Re: This proposed development is for flood defences at key locations along the Carrickmines and Shanganagh rivers including new walls/raised existing walls, culverts, localised screens upgrades and localised works in the river. An Environmental Impact Assessment Report (EIAR) is submitted with application

This proposed Flood Relief Scheme for the Carrickmines-Shanganagh Rivers at sites in the townlands of Woodside, Kilgobbin, Carrickmines, Brennanstown, Shankill, Loughlinstown, Shanganagh and Hackettsland

I refer to the above mentioned proposed development which is before the Commission for approval. Please be advised that the Commission, in accordance with section 175(5)(a) of the Planning and Development Act, 2000, as amended, hereby requires you to furnish the following further information in relation to the effects on the environment of the proposed development:

Figure 9: Section 1-1 Extract JBA Consulting DRWG. No. DR-Z-02932 RevC01

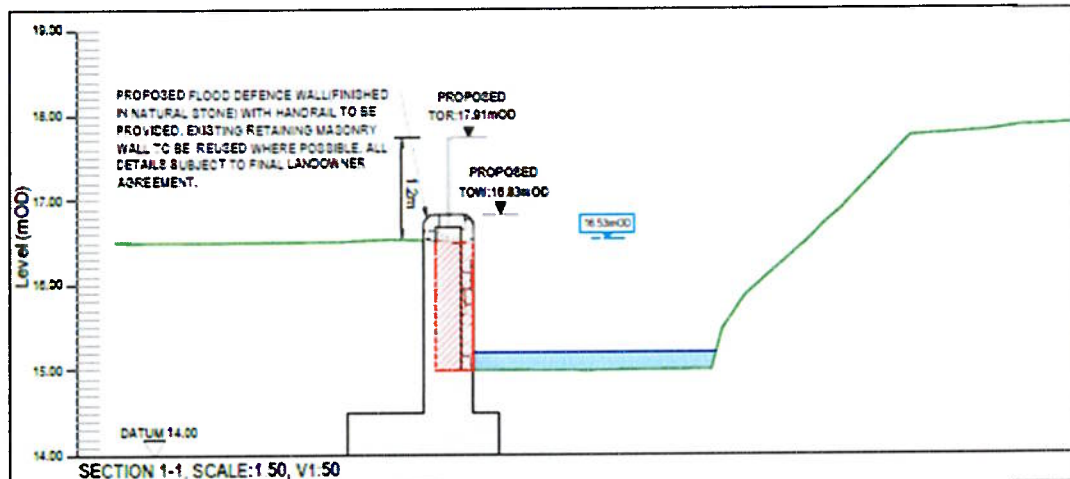
13c(ii)	Clarify the height of the proposed flood wall and railing, by way of additional sections through Waterfall Cottage and Rose Cottage and the adjoining river channel indicating the existing ground level and stone wall at scale of 1:100. Indicate the height of the proposed wall and railing. Details of proposed railings/glass panelling options are desirable.
13c(iii)	At Bray Road, an arched boundary wall, cultural heritage (CH) reference 10, also indicated to be reference 'ADCO Ref 6' in the EIAR Heritage Chapter, crosses the Shanganagh_010. The arched boundary wall includes a gateway at the northern end. Clarify if any works are proposed to the gateway.
13c(iv)	At Brides Glen, clarify extent of wall to be removed on the Bray Road, which is stated to be outlined in cyan, although not detailed in legend, it appears that the bridge which includes a post box is to be removed and reinstated. Both the bridge and letter box are detailed as industrial heritage references (ref. 1018 and 654 respectively in the DLR County Development Plan). Clarify the extent of works to the bridge structure and the post box.

Figure 14.16: Photomontage 4, proposed view at Waterfall Cottage

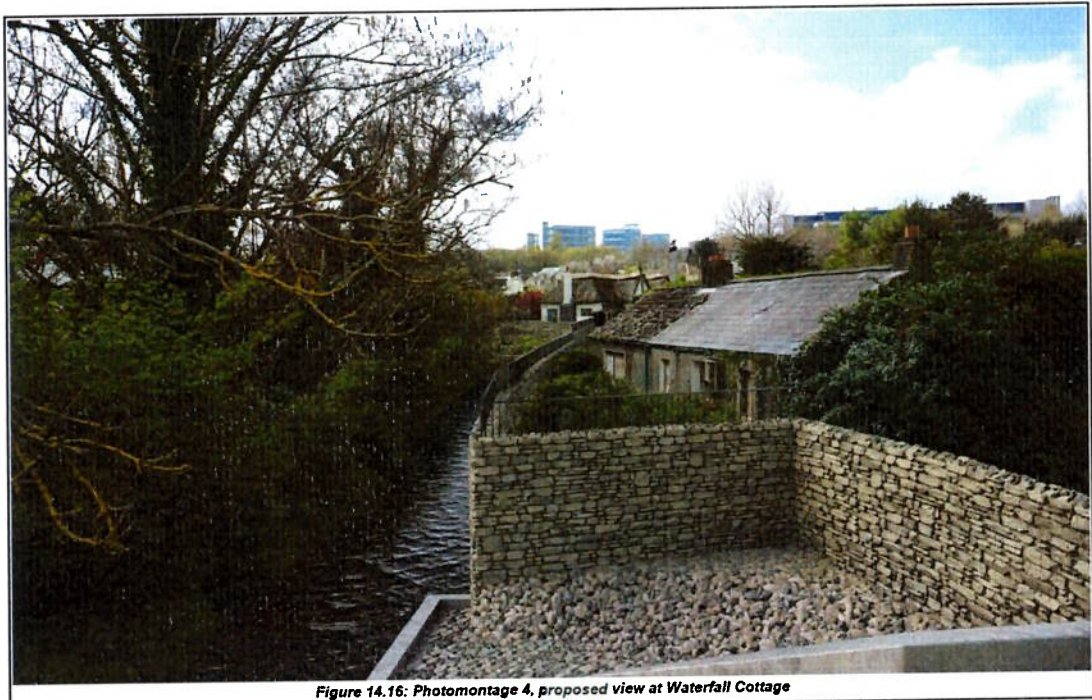
extent on the impact on Priorsland House. A revised an accurate assessment of impact on Priorsland House is required to be submitted, by way of an addendum to the EIAR.
13c	Area 5 – Lower Brides Glen, N11 & Bray Road
13c(i)	The assessment of impact on the character and setting of Waterfall Cottage, a protected structure, is lacking in the EIAR. An architectural heritage impact assessment, in accordance Appendix B of the Architectural Heritage Protection Guidelines for Planning Authorities is necessary. This should be undertaken by a suitably qualified RIAR accredited <u>Conservation Architect</u> . Furthermore, it is considered that the prepared photomontage depicting the proposed wall to the east of Waterfall Cottage is at too great a distance to portray the impact on Waterfall Cottage. Additional photomontages are necessary which clearly represents closer visualisations of the proposed wall on Waterfall Cottage.
